October 26, 2022

**Re: Project no. PR-2022-007701, Application no. SI-2022- 01868
New Branch office for Nusenda Credit Union at 2801 Juan Tabo NE, Abq NM.**

The following are responses describing how we comply or are addressing staff comments to follow IDO and other requirements for site plan approval:

SITE DETAILS

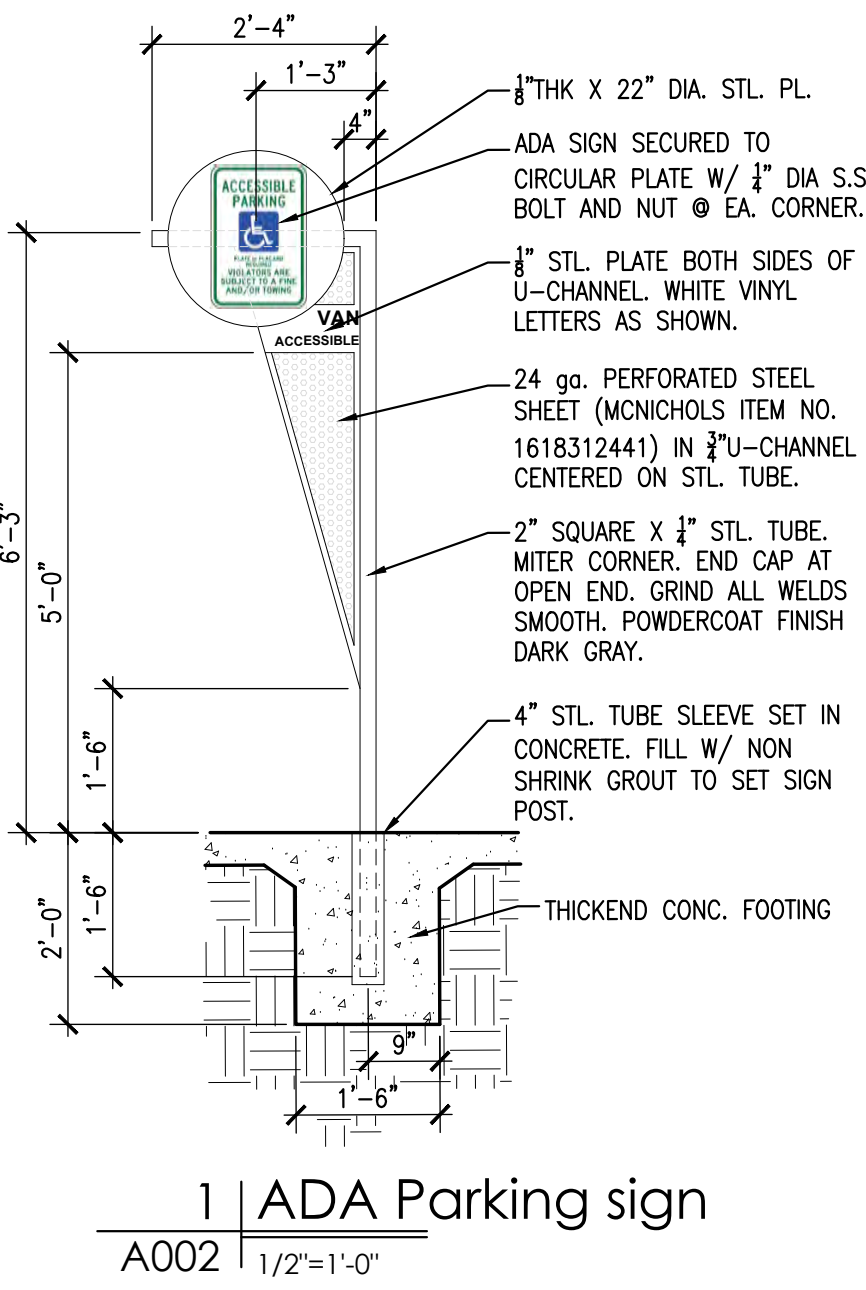
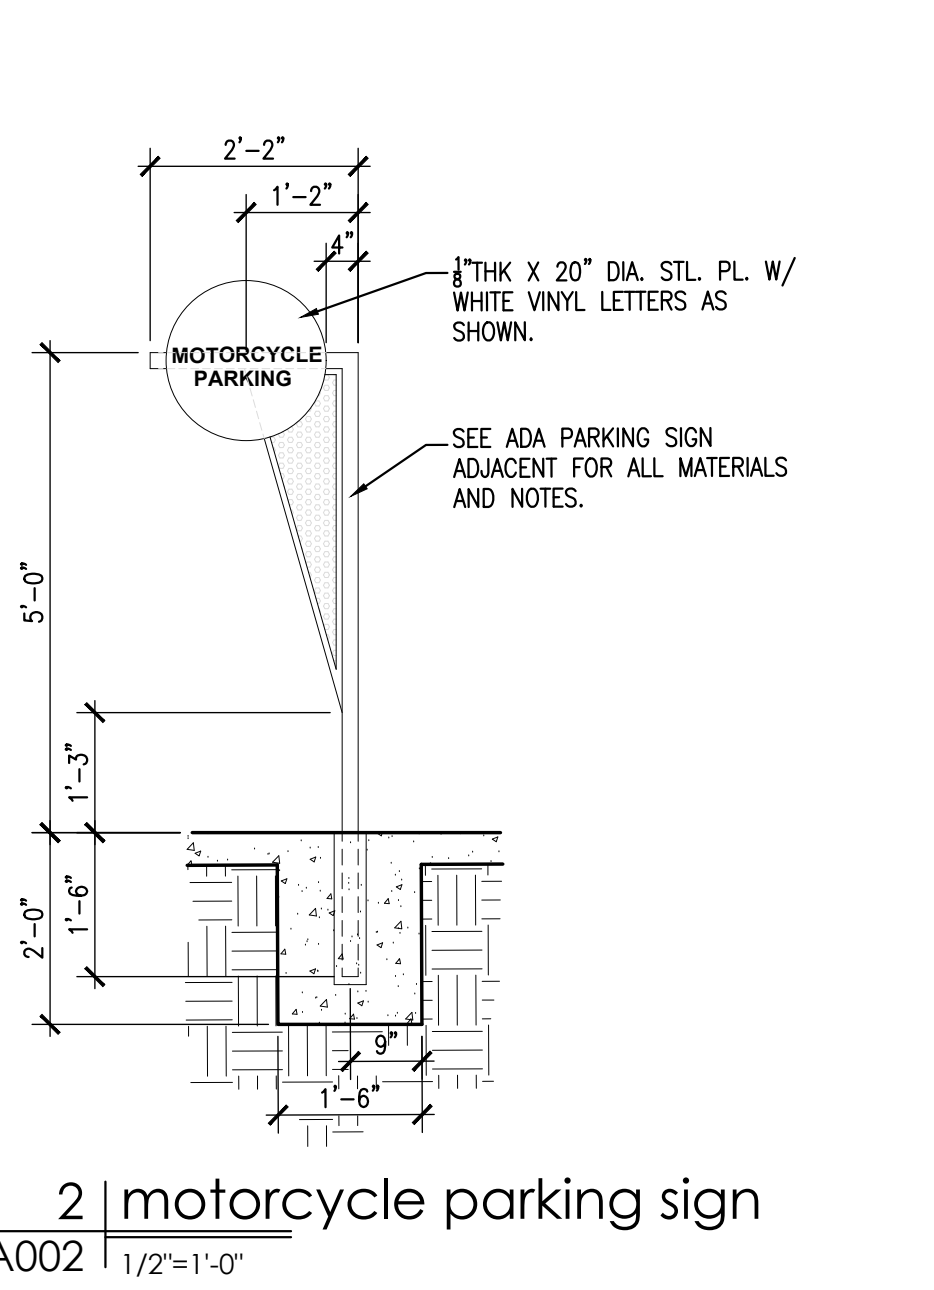
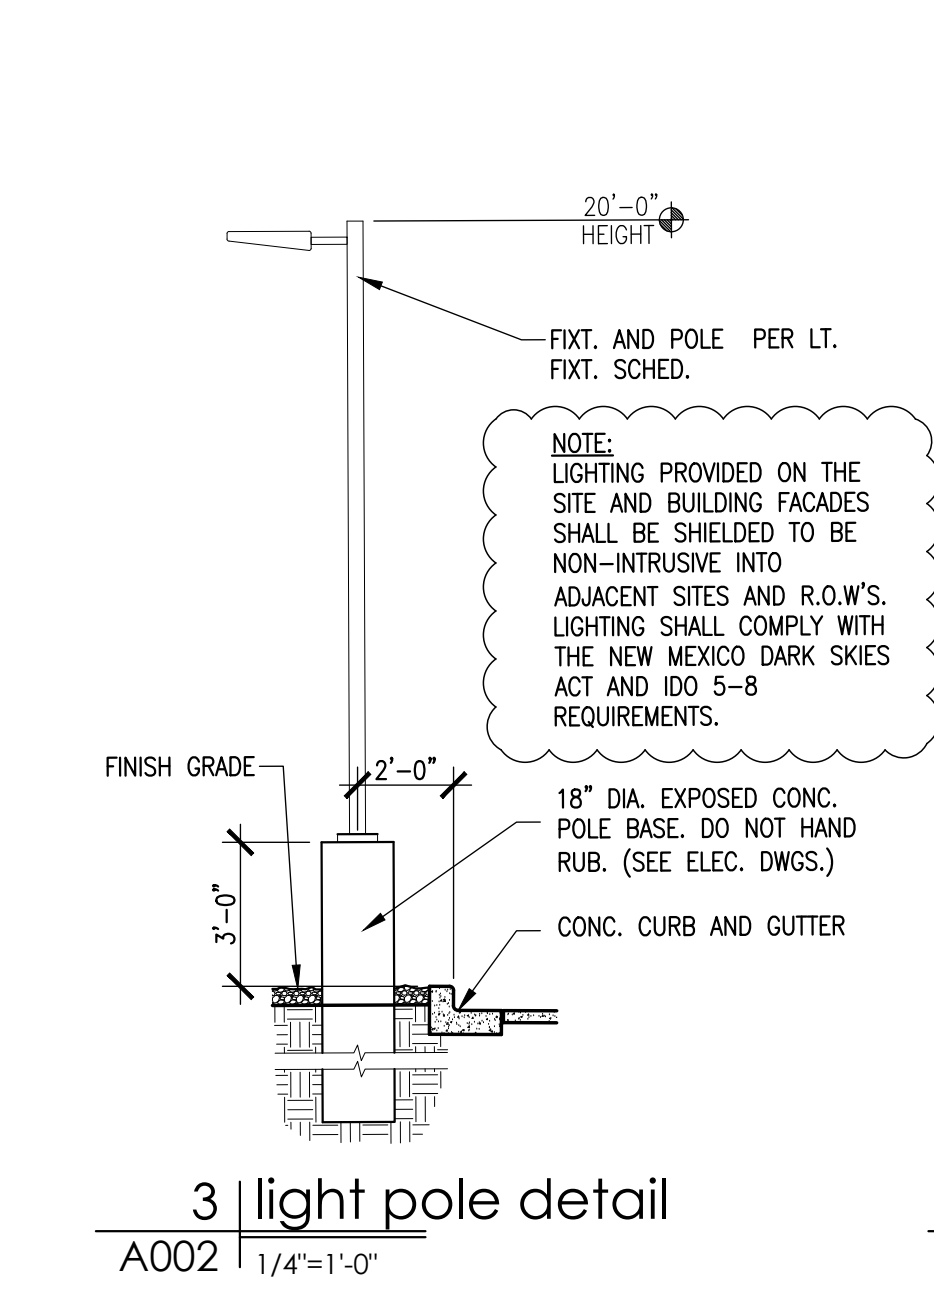
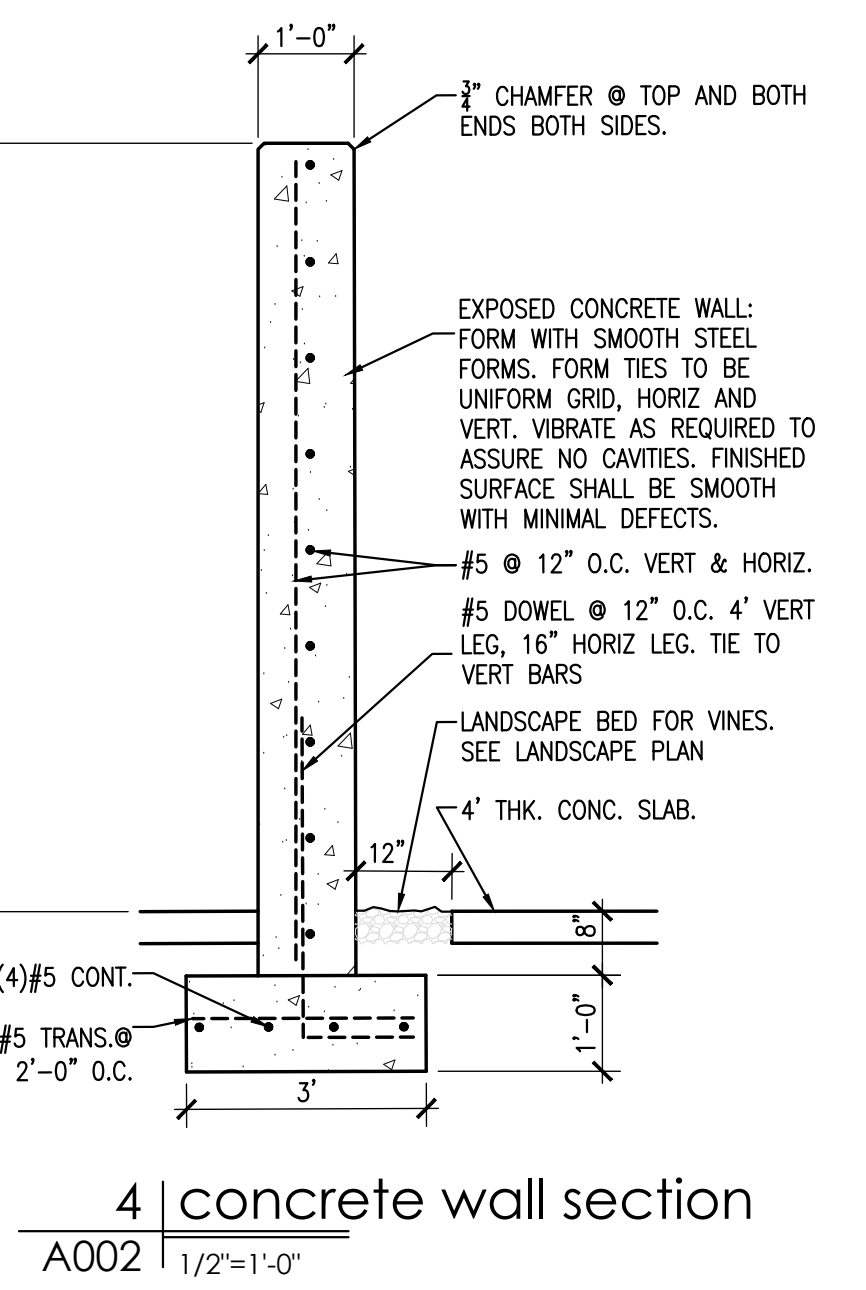
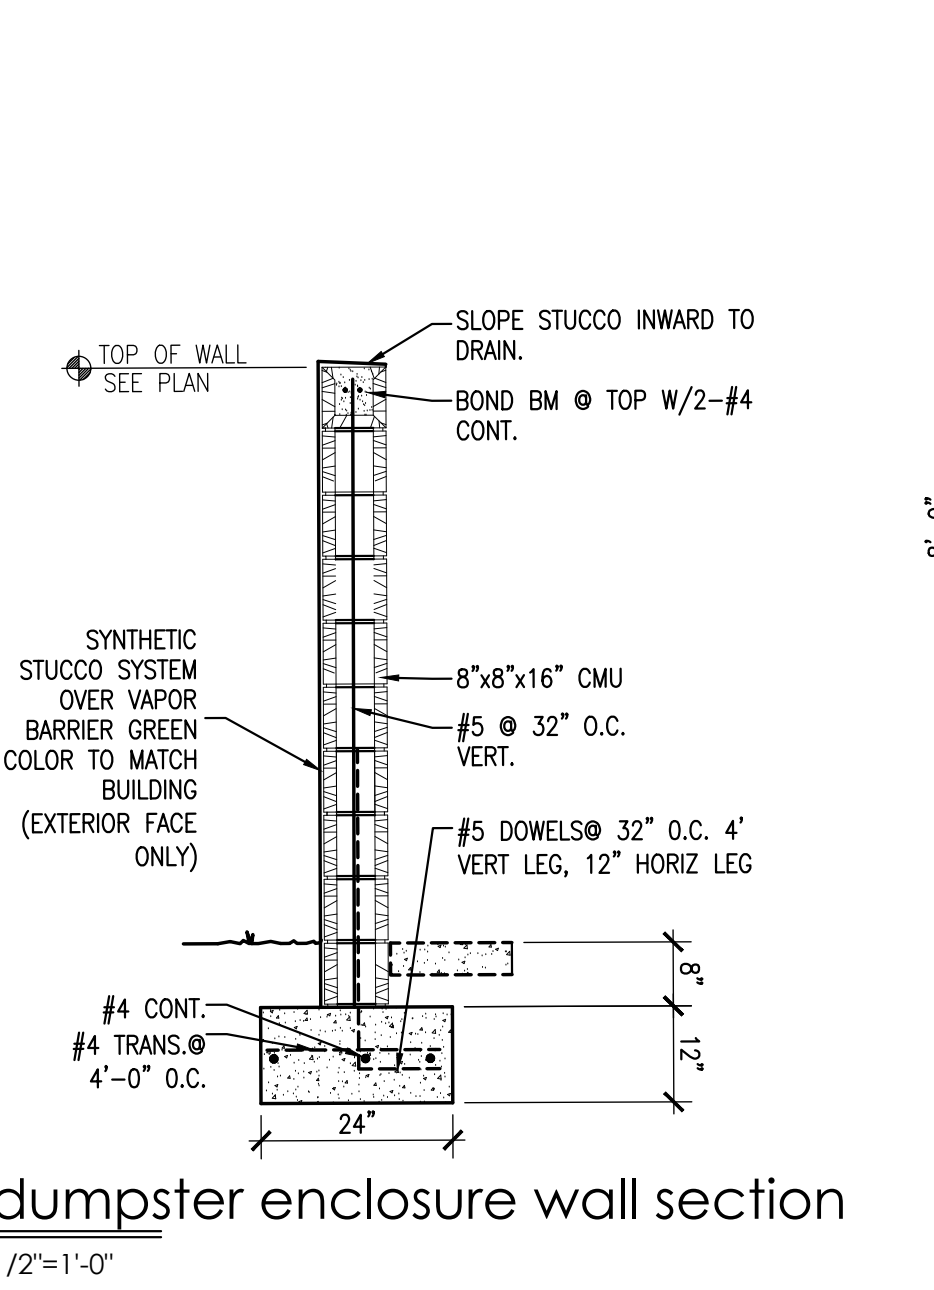
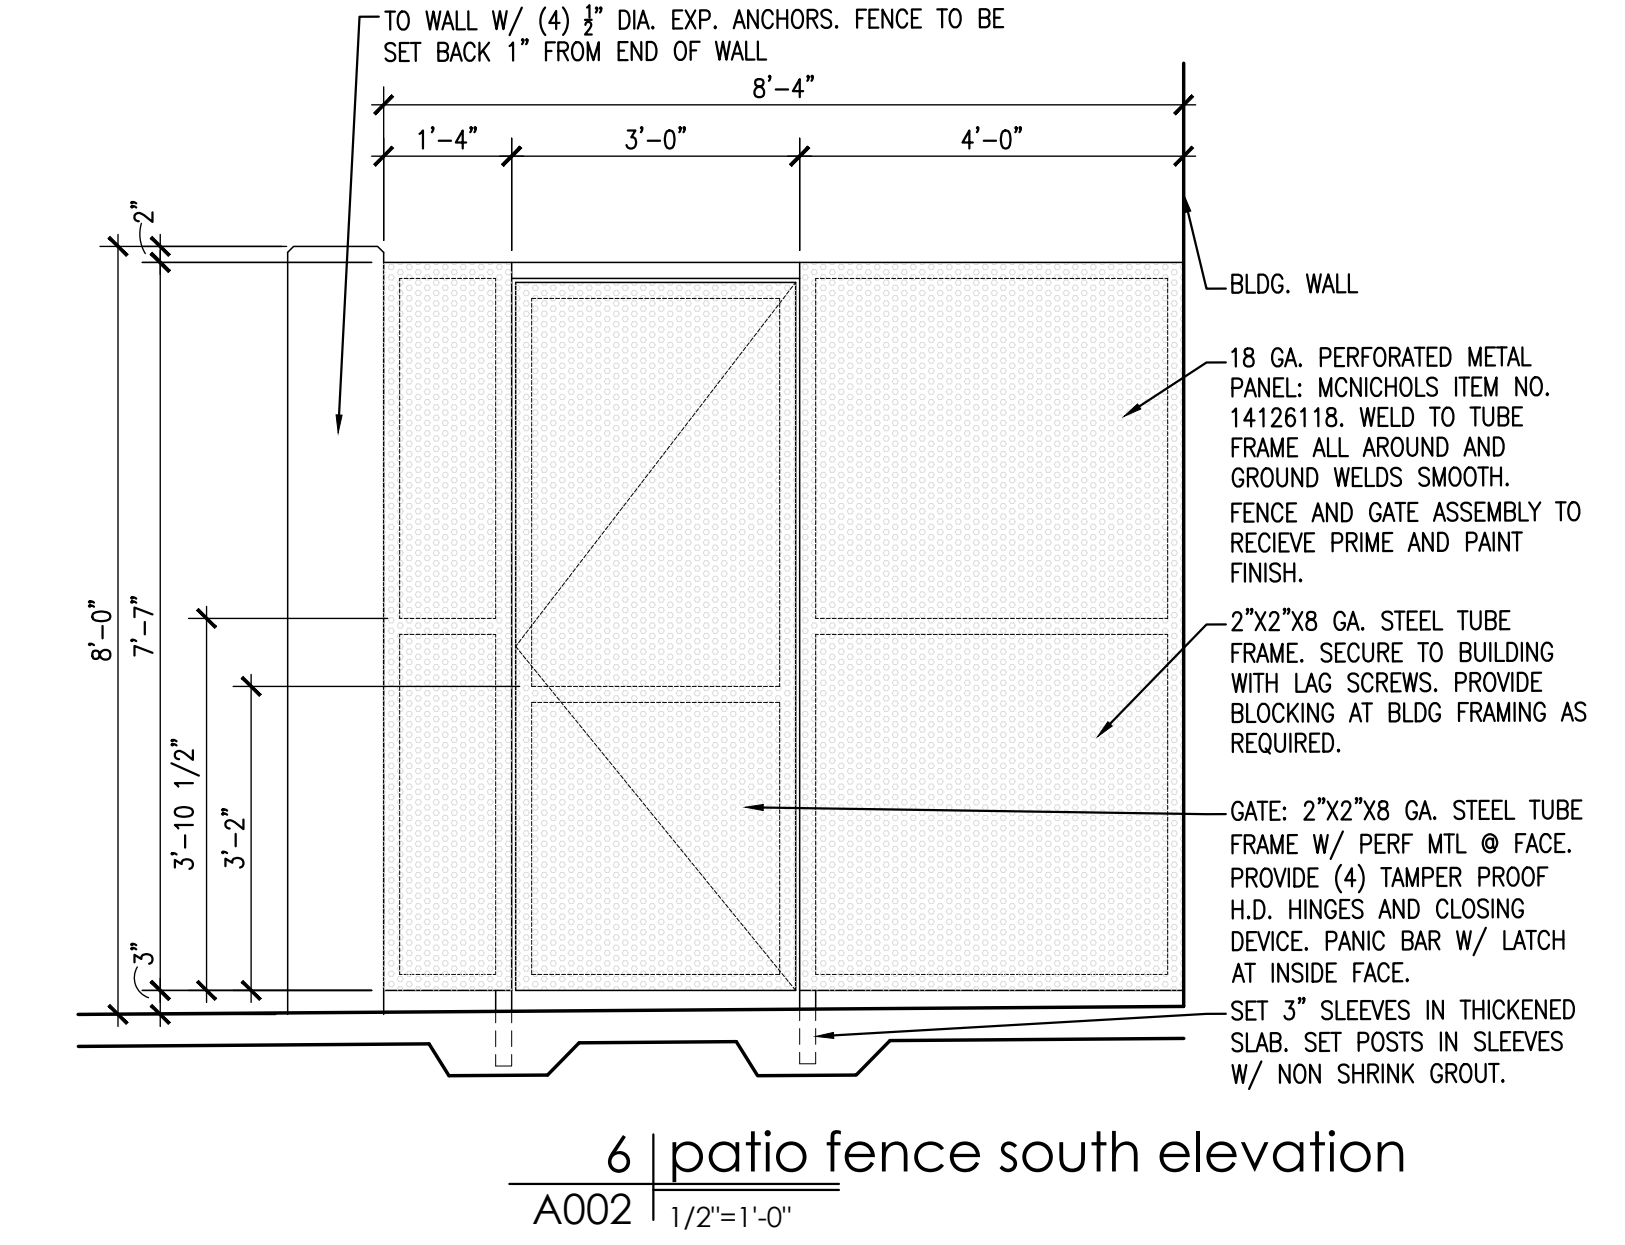
1. 20 shrubs and 10 street trees are shown on the landscape plan at the south property line. These are in a landscape buffer that is 15' wide. It is our position that the shrubs and trees, once mature will provide adequate screening.
2. A note has been added to detail 3/A002 to comply with all night sky ordinances and IDO 5-8 requirements. (attached)
